Application number: 2021/90299	
What is the application for?:	Demolition of existing dwelling and erection of detached dwelling with integral
Address of the site or building:	154, Gomersal Lane, Gomersal, Cleckheaton, BD19 4JQ
Postcode:	BD19 4JQ

Type of comment: An objection	
Do you wish your comments to be published on the website anonymously?	No

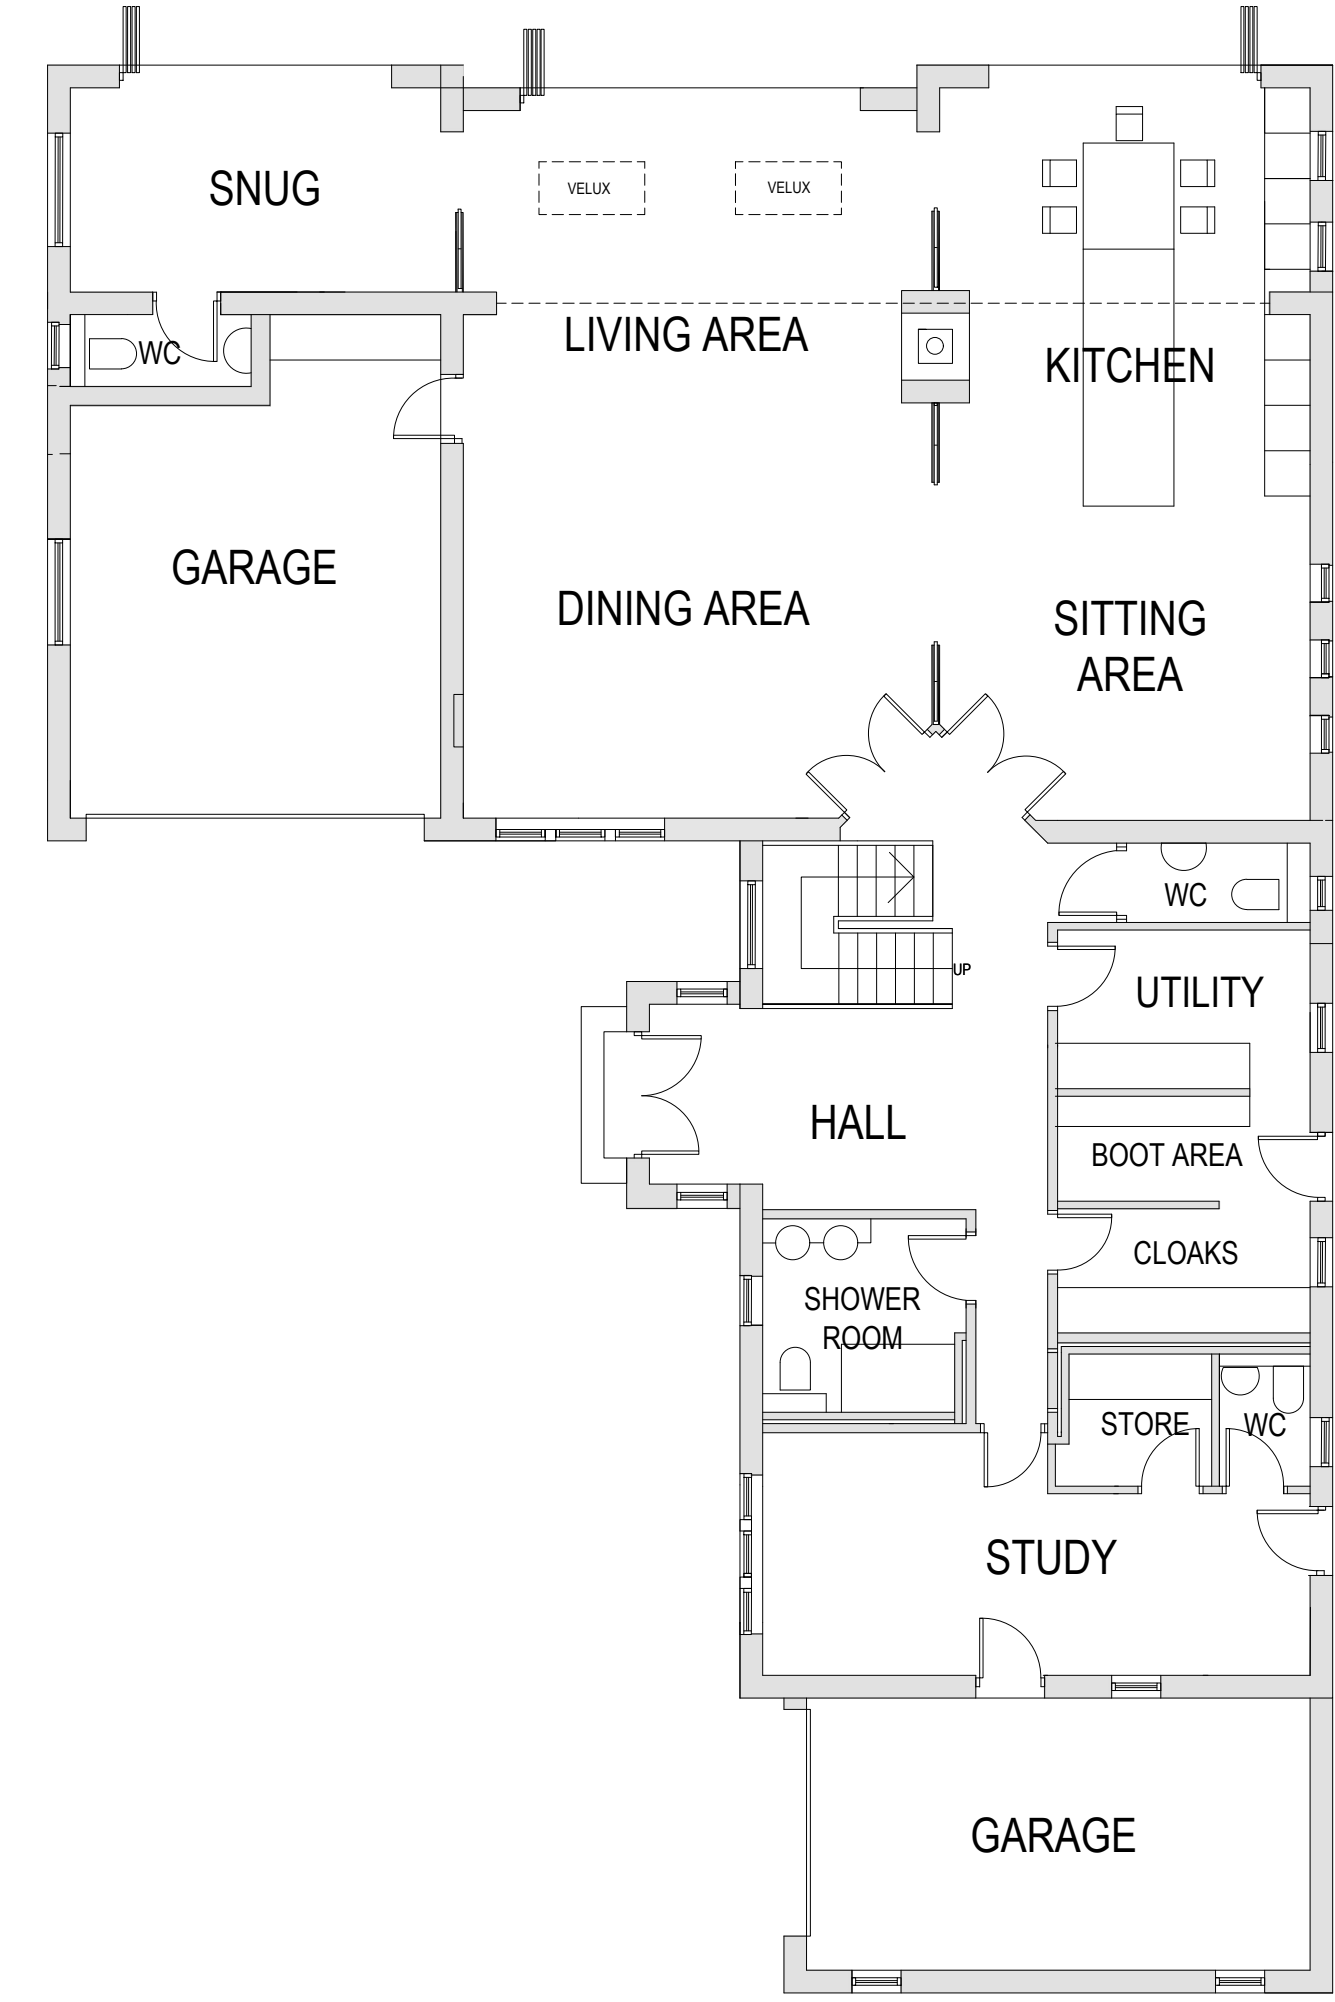
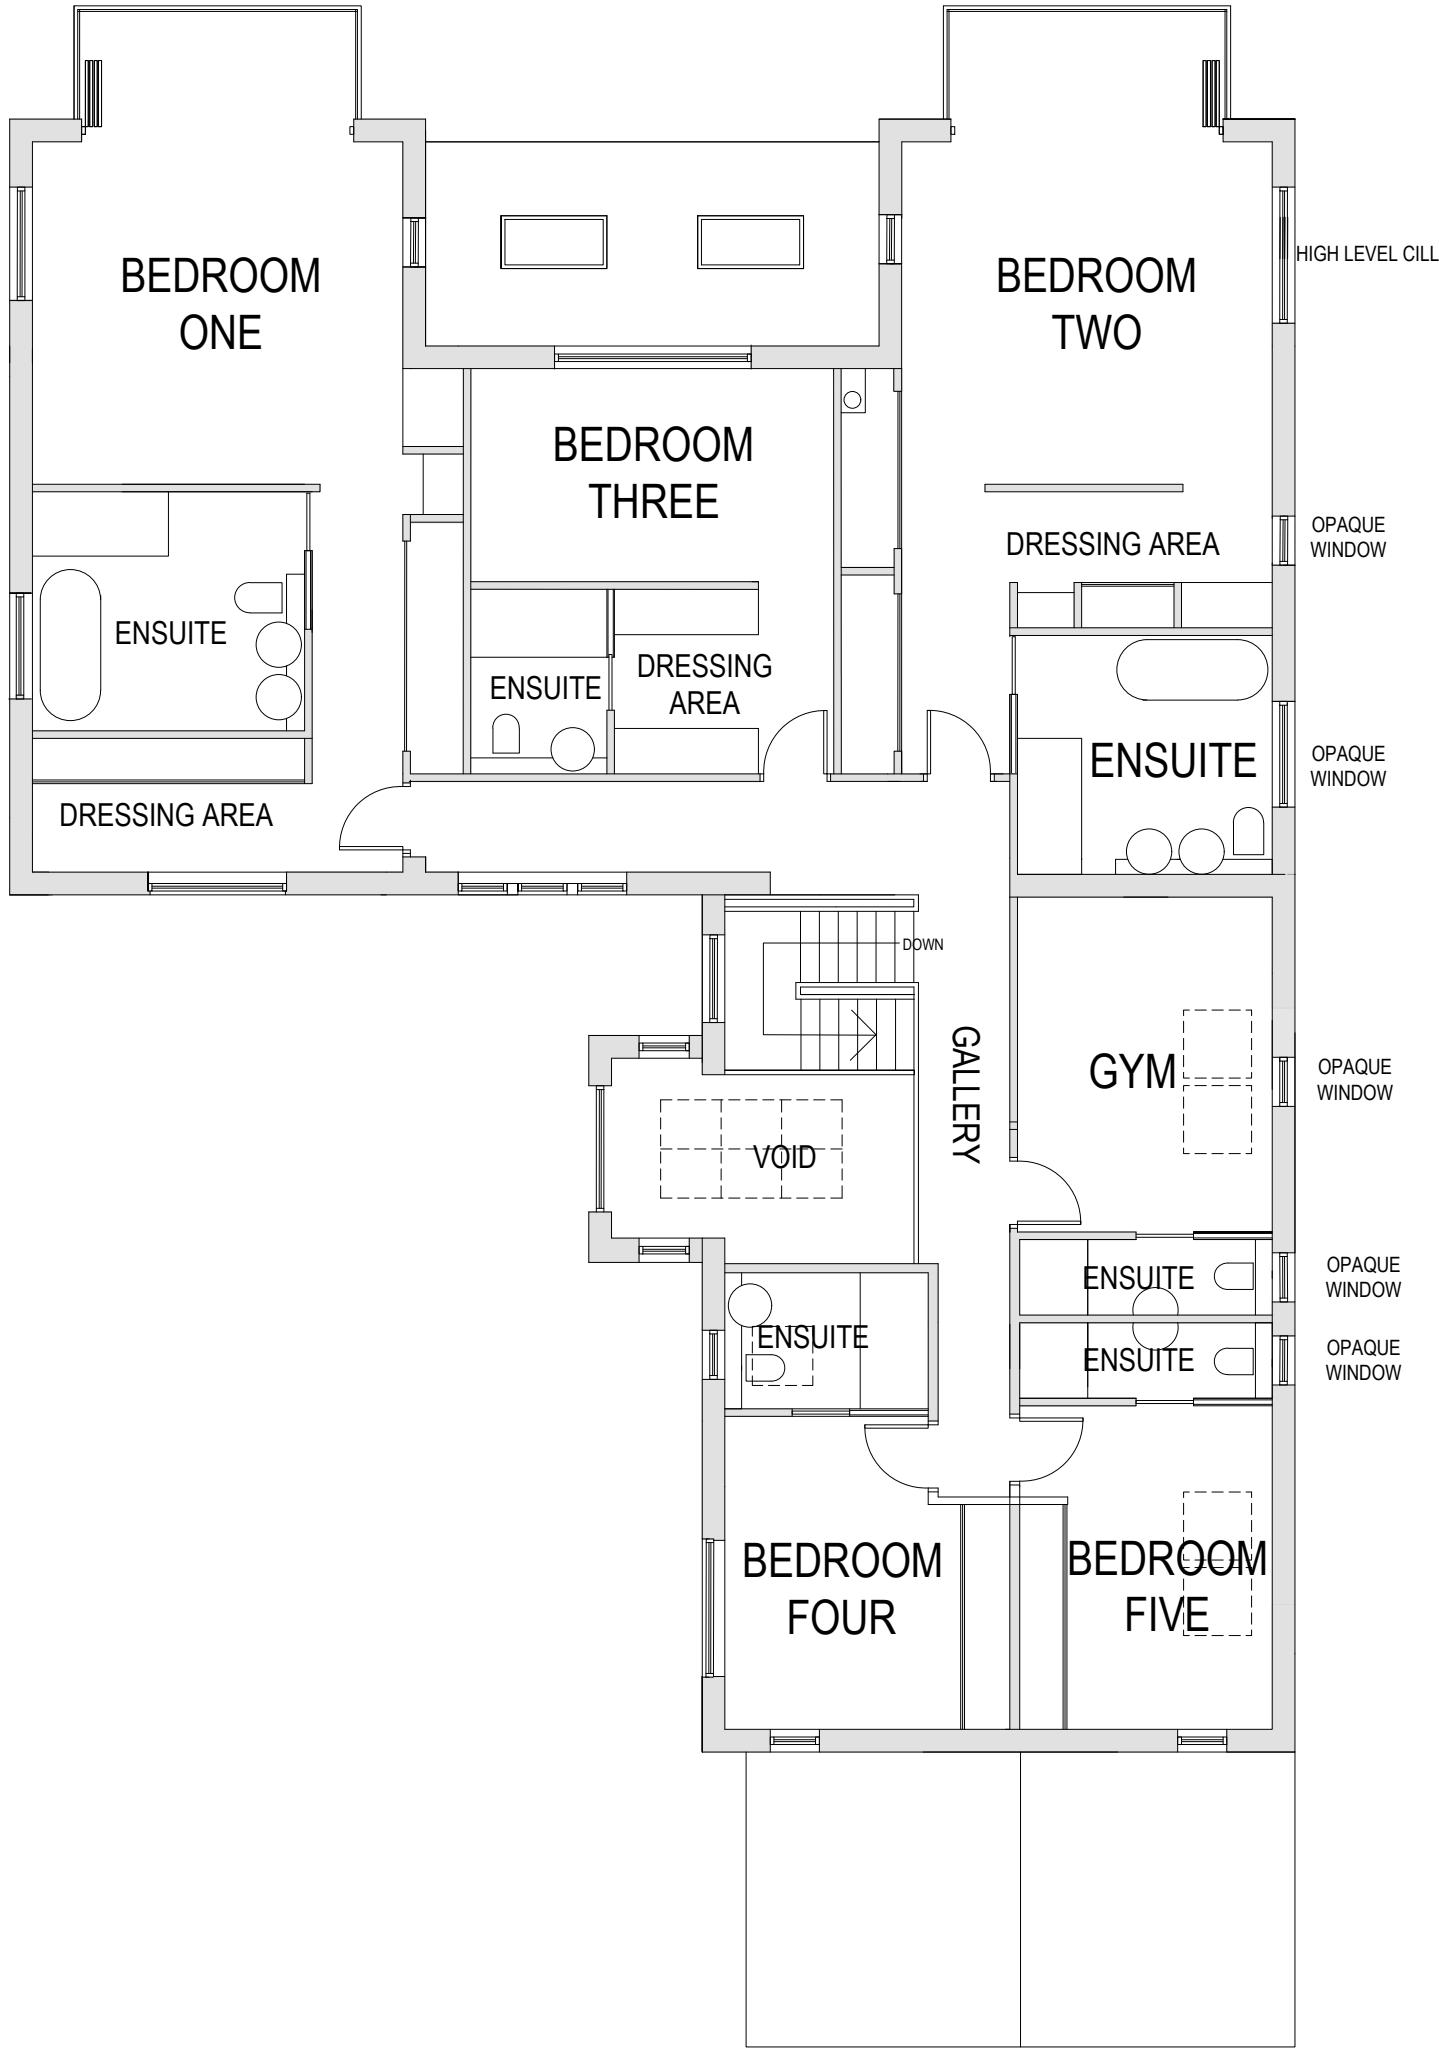
2. Design, appearance & layout- Although the neighbouring property to the West is a two storey building, the applicants building is a mirror image of the existing neighbouring bungalow to the East. The proposed two-storey development will overshadow the existing bungalow, & considering the proposed development is the first building you see as you enter Gomersal Lane, although the footprint is of similar position, the development is more than double the size of the existing building therefore creating an imposing, over-bearing impression to both adjacent properties in terms of both proposed footprints & elevation. The space could easily be condensed by the removal of the unnecessary number of bathrooms & spare rooms that have clearly been designed to double up as bedrooms- how will this even comply with the Building Regulations Water Efficiency calculations? Should a smaller more conservative building be proposed to fit more seamlessly into its surroundings then I would be willing to remove this objection.
